MONUMENT ACADEMY MIDDLE/HIGH SCHOOL

DEVELOPMENT PLAN

ENLARGED SCHOOL SITE DEVELOPMENT PLAN

Markup Summary

ENLARGED SCHOOL SITE DEVELOPMENT PLAN

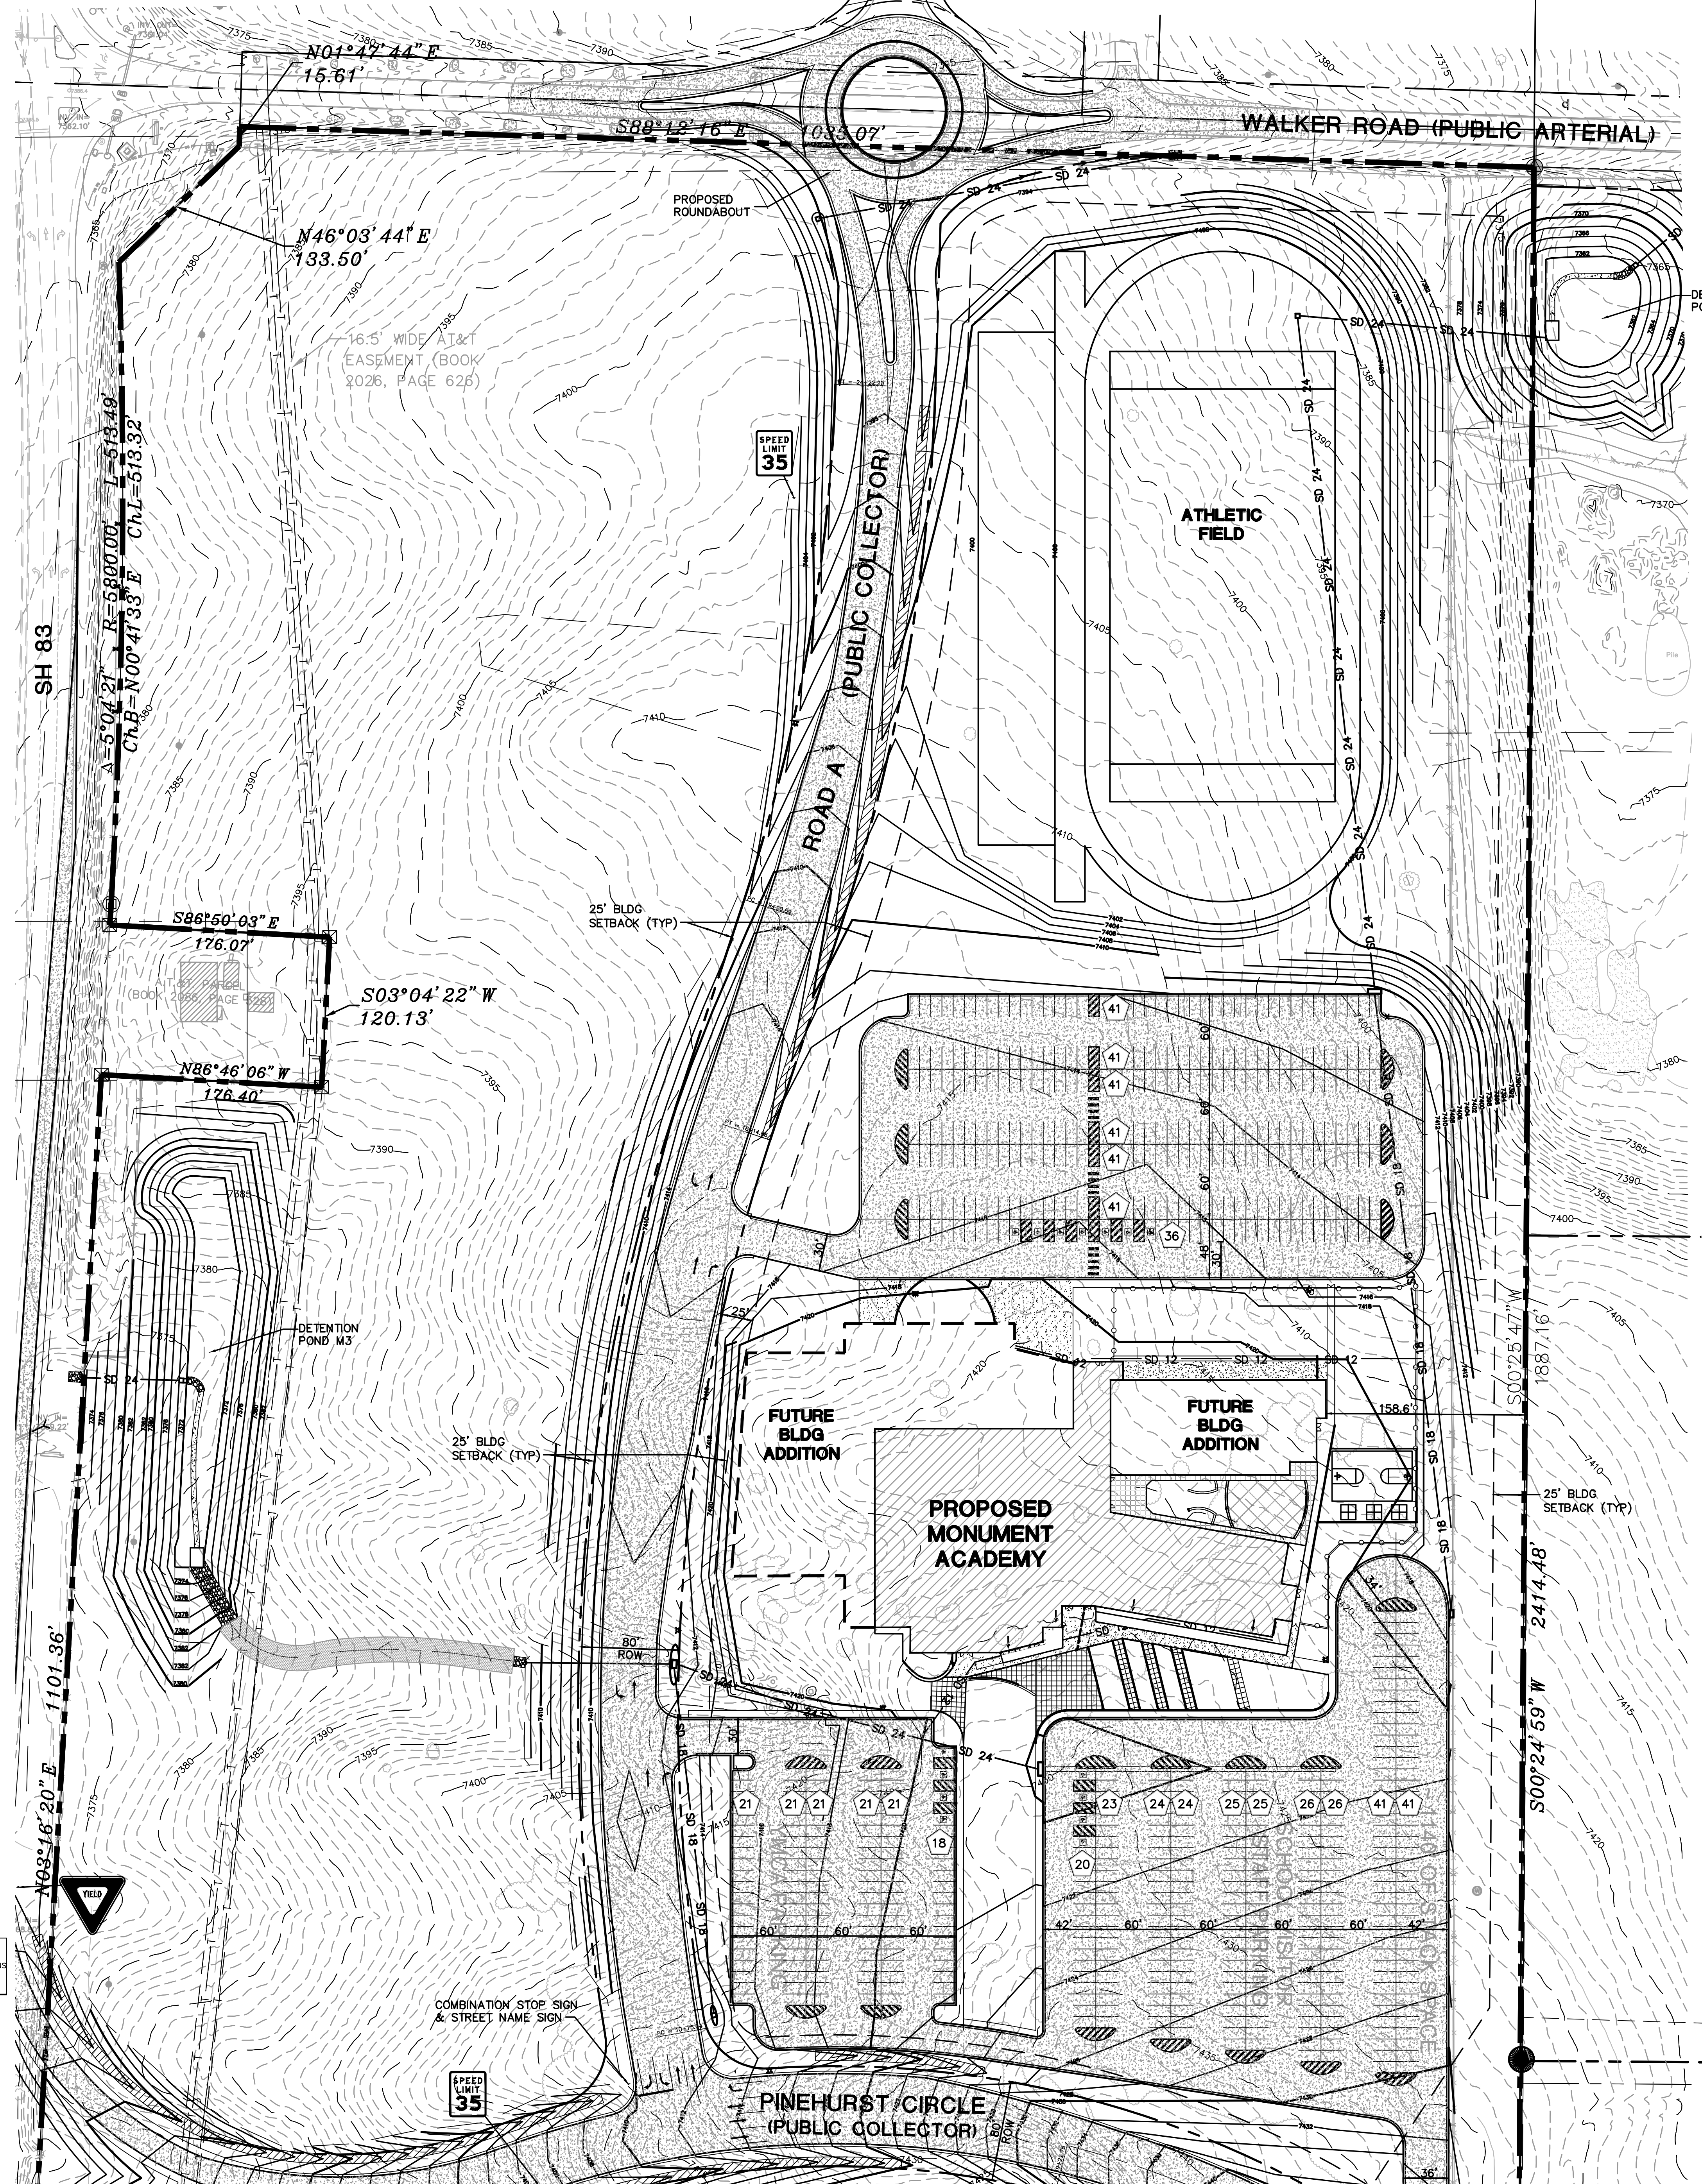
How does trail connect to school site?

Consider using larger radius centerline curve. Verify design vehicle tracking paths. See sight distance comments on CDs.

Show and label only the proposed improvements. Future road may be indicated with dotted or light dashed lines.
